CITY OF PORTLAND BUILDING PERMIT

Located At 20 BALLPARK DR

Job ID: 2012-05-3891-SF

has permission to build a new Two Story Single Family F
provided that the person or persons, firm or corporation
the Statues of Maine and of the Ordinances of the City o
the buildings and structures, and of the application on fil

ROOF FRAMING PLAN SCALE: 1/4"=1'-0"

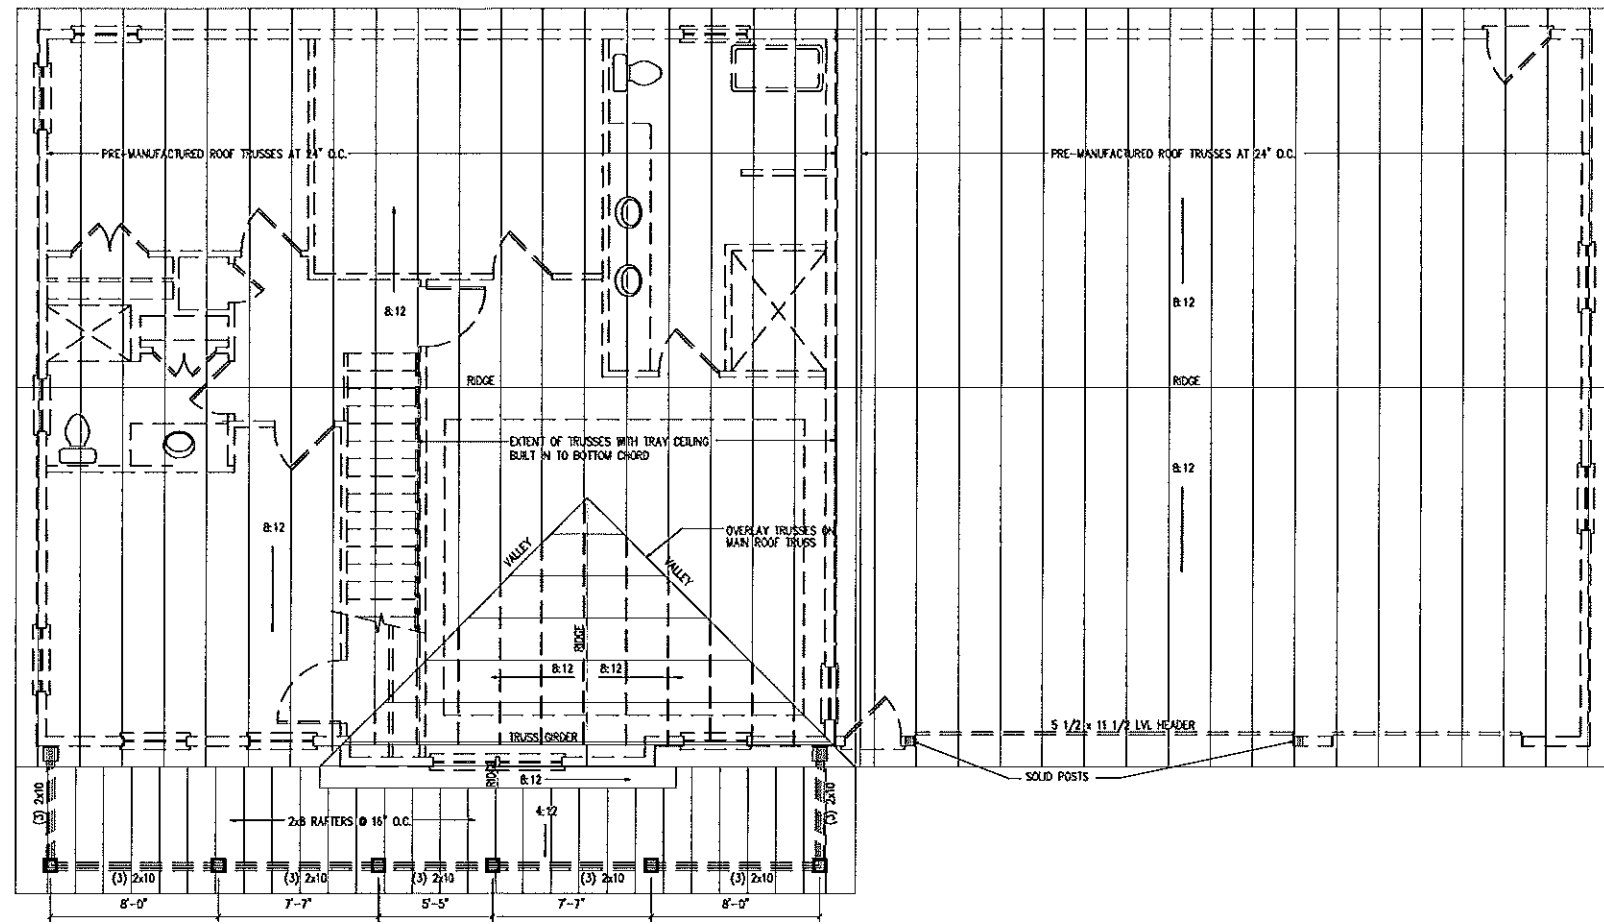
Attic or additional Floor Joist Species Dimensions and Spacing (Table R802.4(1) and R802.4(2))	Trusses	1 Specs Needed

- R807.1 Attic access. Buildings with combustible ceiling or roof construction shall have an attic access opening to attic areas that exceed 30 square feet and have a vertical height of 30 inches or greater. The vertical height shall be measured from the top of the ceiling framing members to the underside of the roof framing members. The rough-framed opening shall not be less than 22 inches by 30 inches and shall be located in a hallway or other readily accessible location .I believe it is shown on the plan in the large walk in master closet.
- Ventilation of this space is required per ASRAE 62.2 , 2007 edition. It should meet, it has continuous ridge vent and eaves
- Insulation shall comply with the IECC, 2009 (Maine State Energy Codes). It meets all new energy code insulation.

With the truss specification does the attic meet the criteria below? Space is unfinished and only accessible from the scuttle.

1. The occupiable floor area is at least 70 square feet, in accordance with Section R304,
 2. The occupiable floor area has a ceiling height in accordance with Section R305, and
 3. The occupiable space is enclosed by the roof assembly above, knee walls (if applicable) on the sides and the floor-ceiling assembly below.
- The basement egress must open directly into a public way, or to a yard or court that opens to a public way (not the garage) This is not finished space, therefore doesn't need to meet egress.
